**METROLINK Railway Order
An Bord Pleanála Oral Hearing**

ABP-314724-22

**Wynn's Hotel, 35-39 Abbey
Street Lower, Dublin 1, D01 C9F8.**

Client:	Wynn's Hotel
Project Title:	Metrolink Oral Hearing
Document Title:	Written Submission
Document/Job No:	JSA 22111 Ref Final

Drawing Title  
**Figure 14.2 Groundborne Noise from Tunnel Boring Machine**  
Sheet 1 of 7

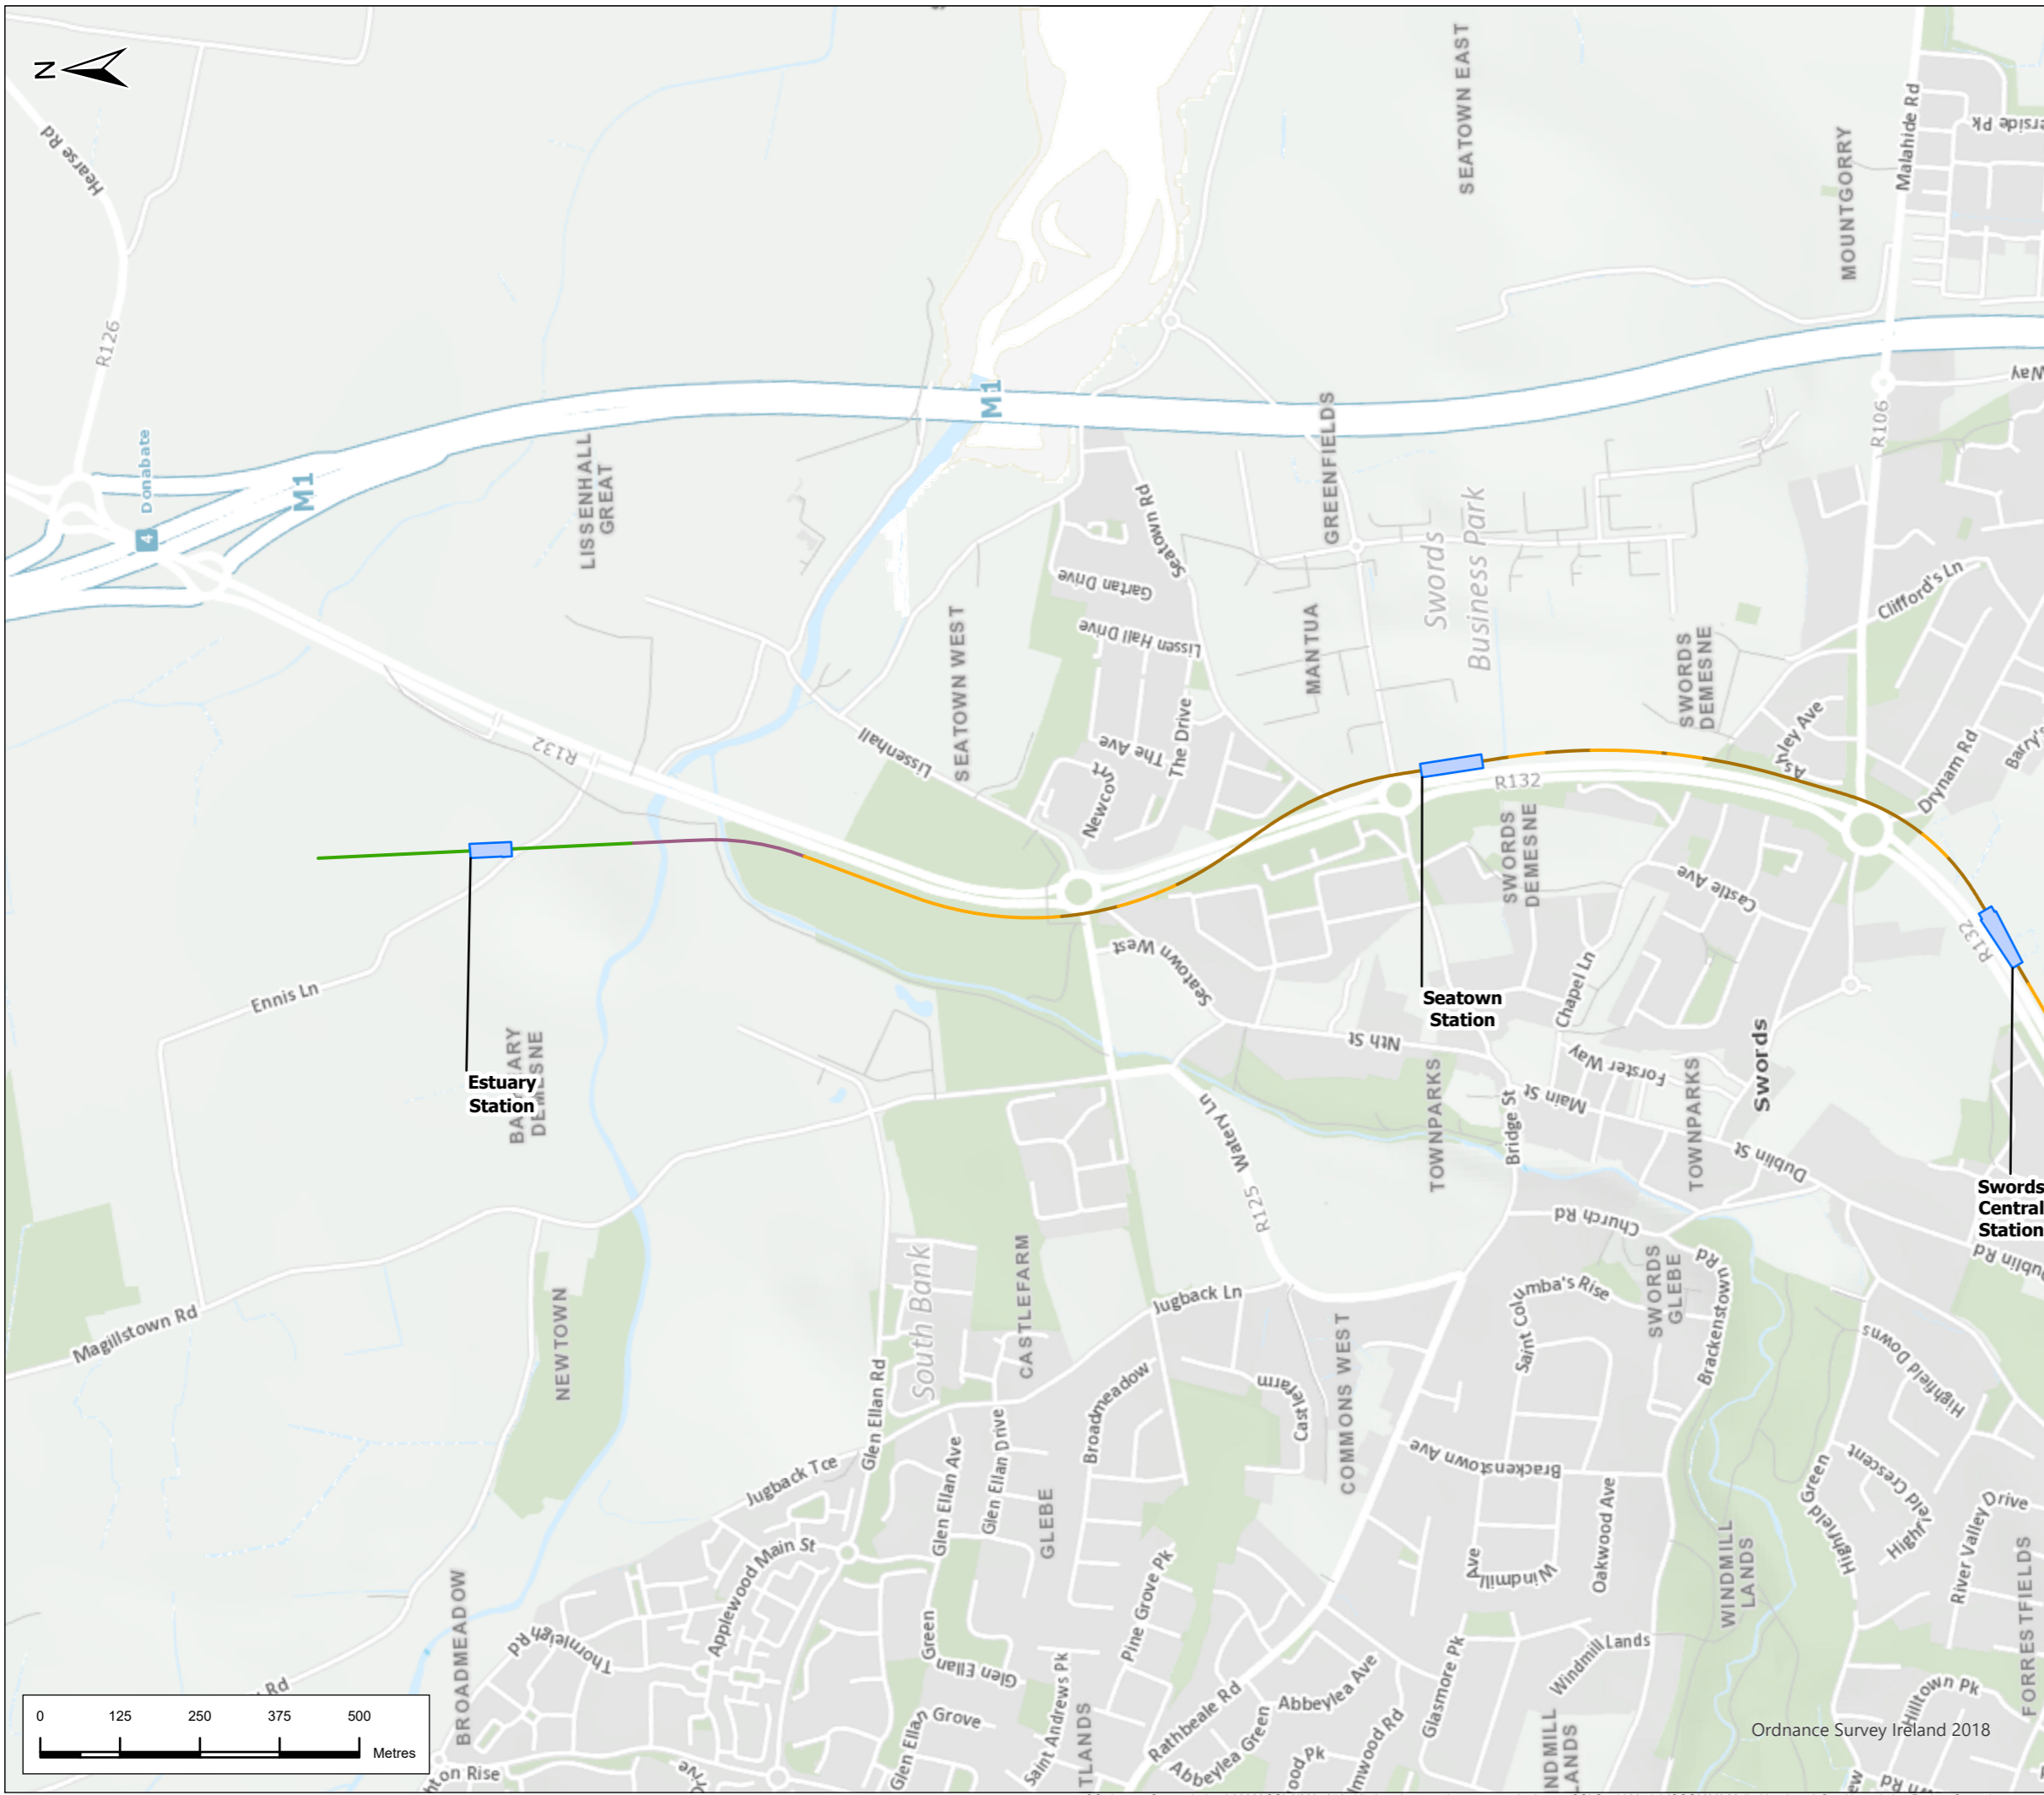
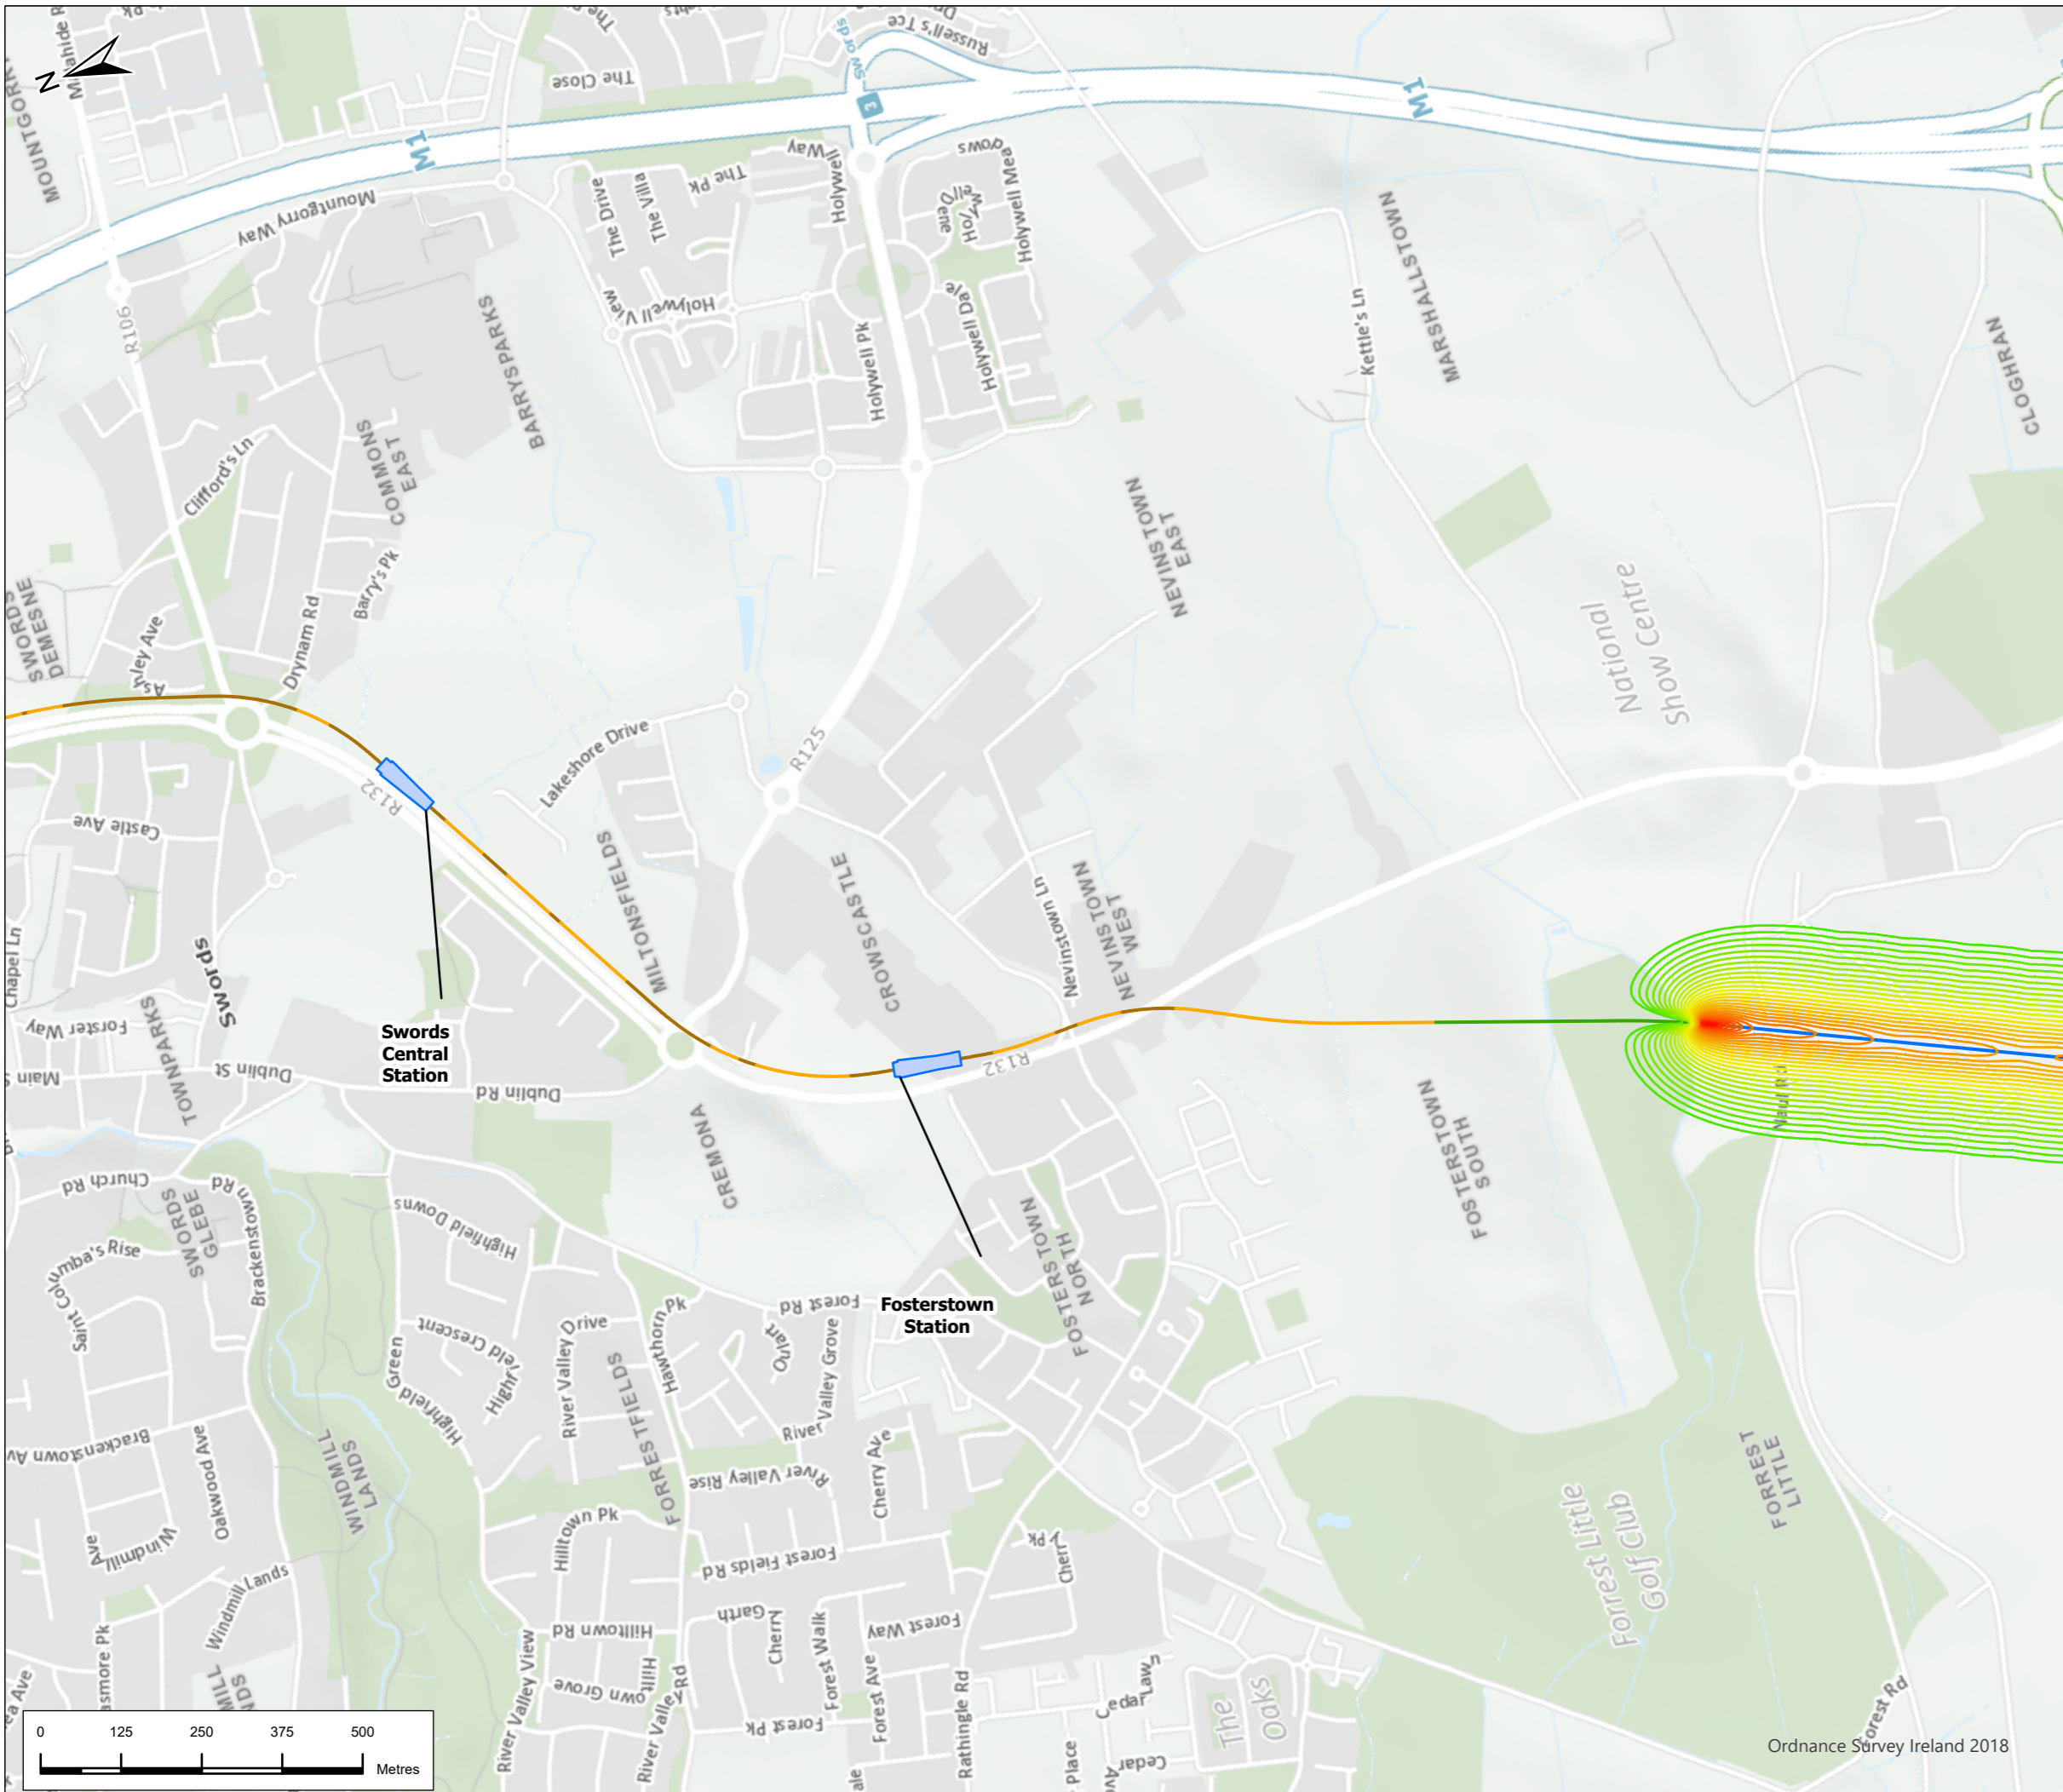
"The predicted maximum level of groundborne noise at ground floor level is around 55dBL_{Amax,S}. This would be expected to attenuate by around 2-3dB per floor, moving up through the building and so may exceed the assessment criterion of 45dBL_{Amax,S} on all floors when tunnelling directly below the hotel. The predicted level is consistent with EIAR Figure 14.2.

Groundborne noise will exceed the criterion as the TBM approaches and moves away from the hotel, as well as when directly beneath it, for a total drive length of approximately 90-100m. Based on information in the EIAR, this could be for a period of around two weeks.
